T-Bone Construction, Inc.
1310 Ford St.
Colorado Springs, CO 80915
(719) 570-1456 Fax (719) 591-5217
9 October 2020

LETTER OF INTENT

Letter of Intent_V1.pdf Markup Summary

AS REPLATTED

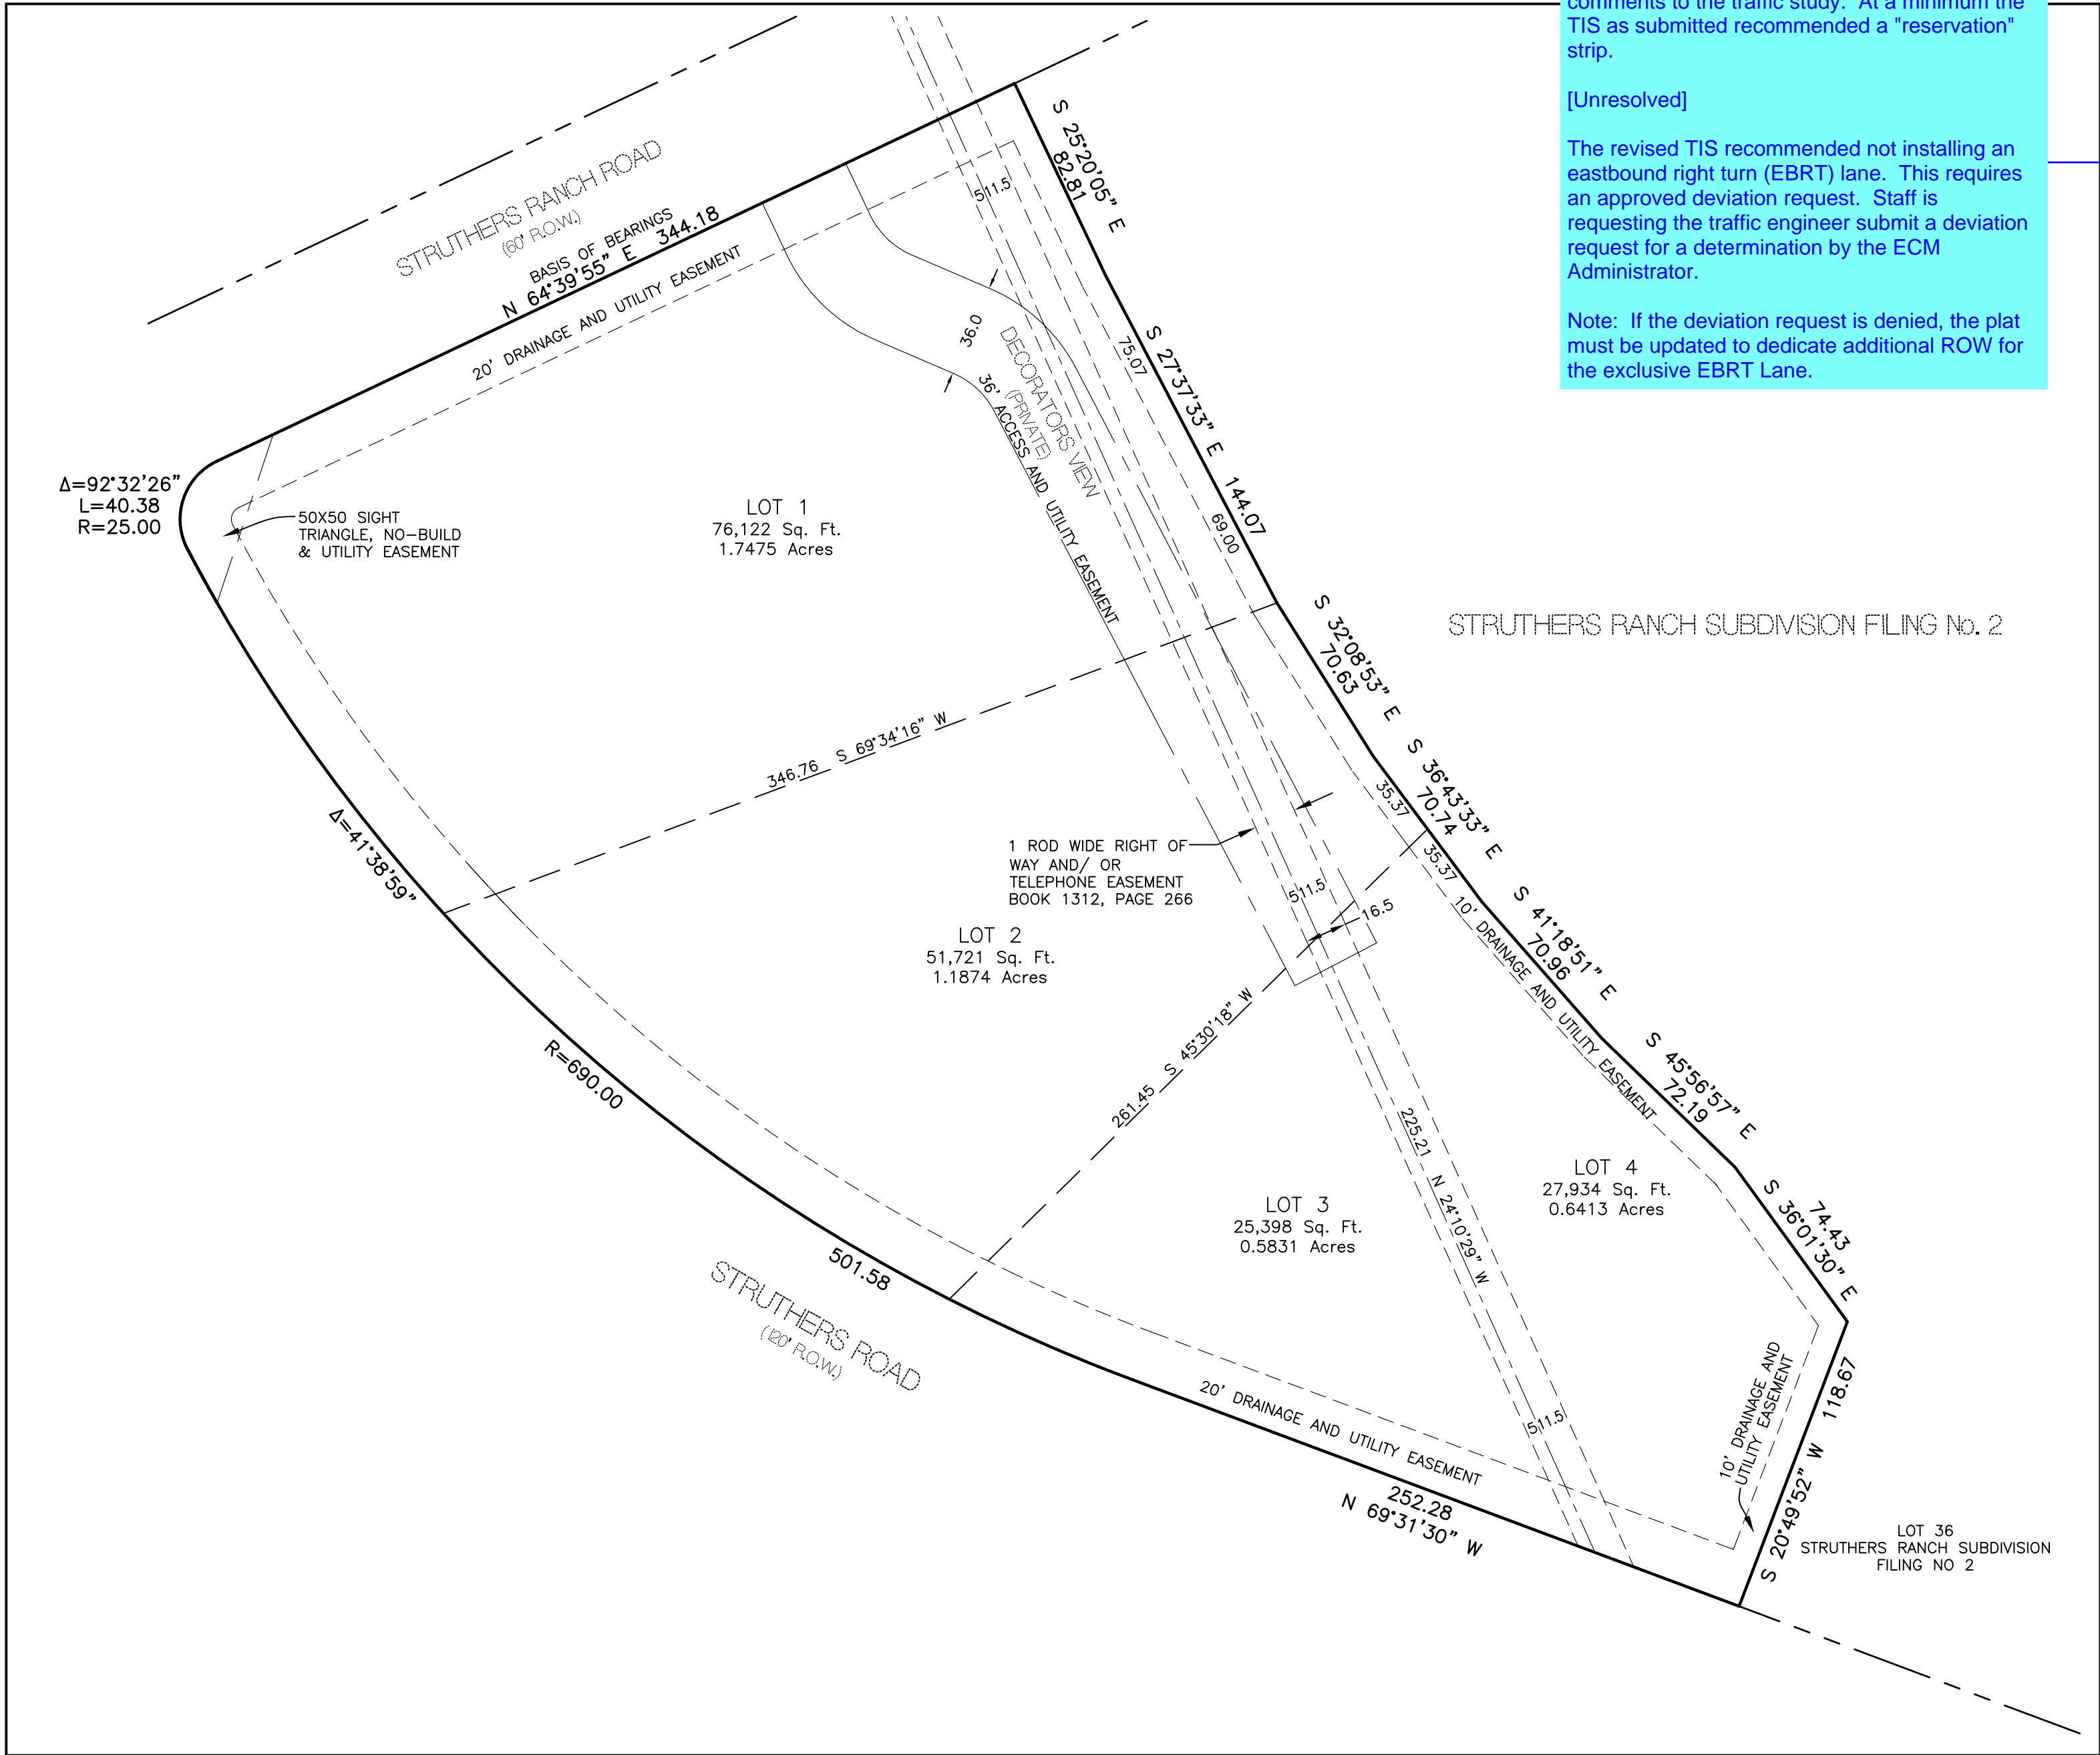
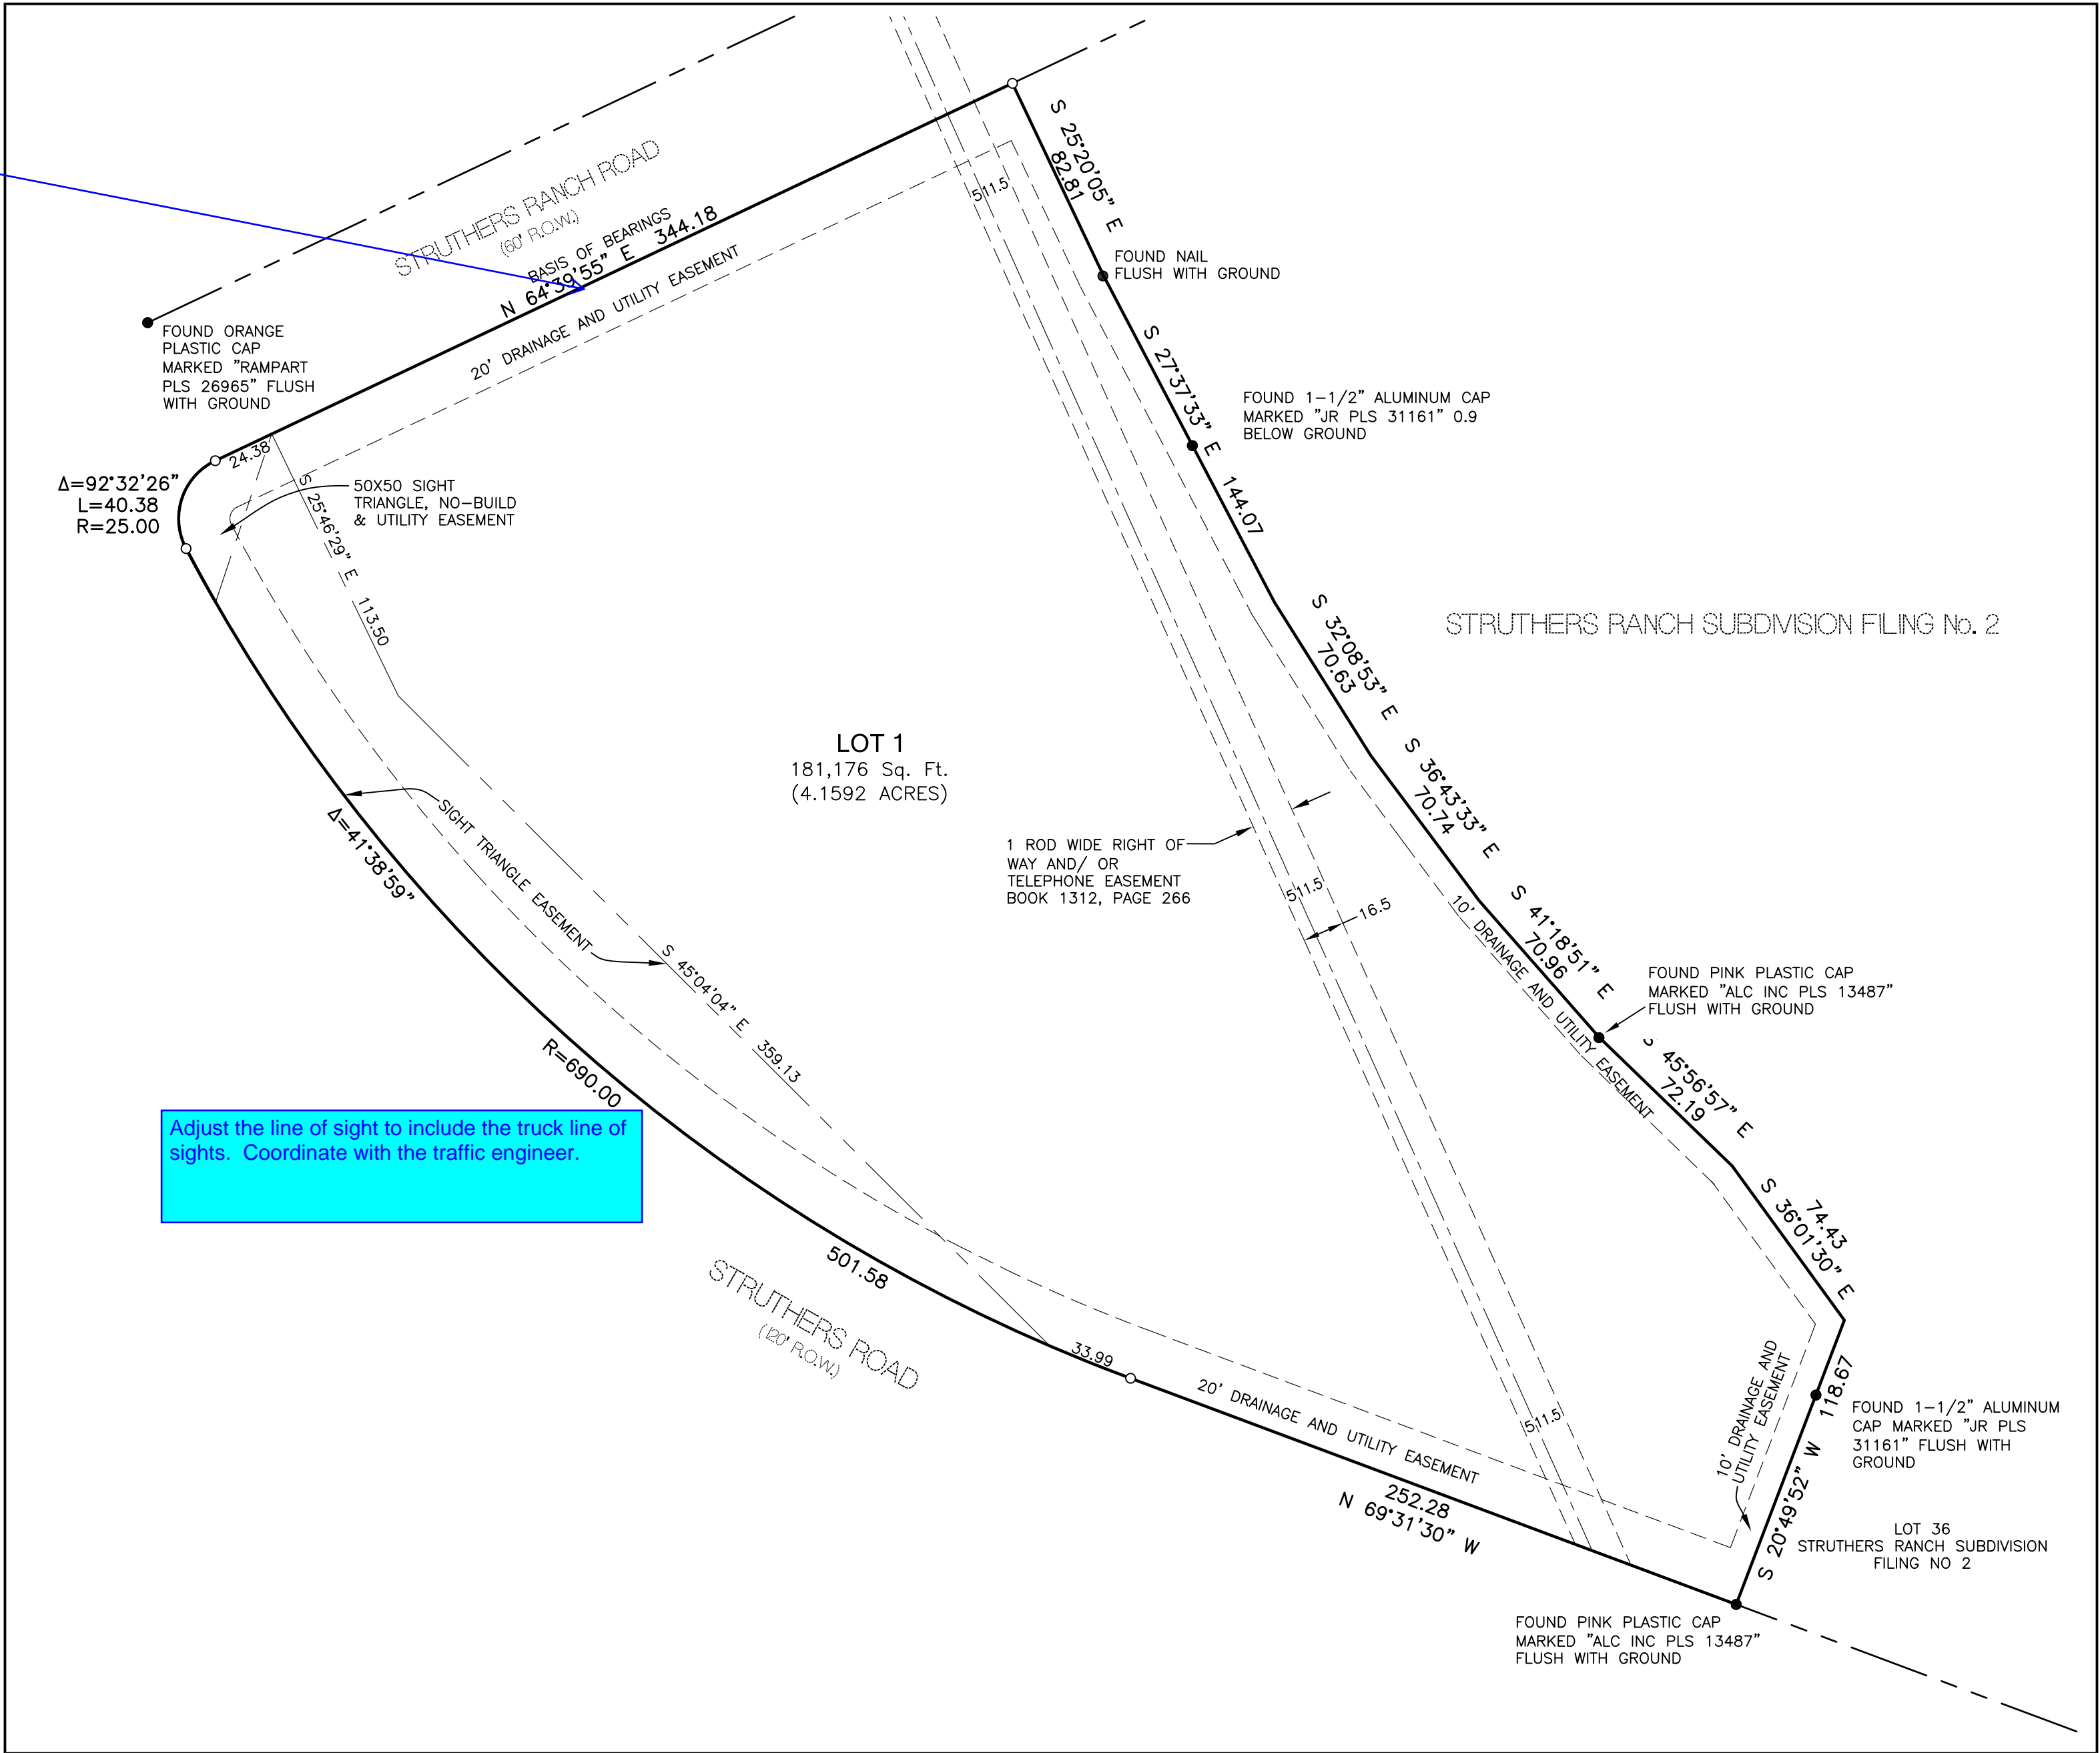
No direct lot access is permitted on Struthers Road. Staff does not see an undue hardship requiring this deviation from the engineering criteria manual. This deviation request will likely be denied by the Engineering Review Manager. Staff recommends withdrawing this request.

If the applicant chooses to pursue the request, then complete and submit the deviation request form to obtain an official determination by the Engineer Review Manager. The request form must be stamped/signed by a licensed professional engineer.
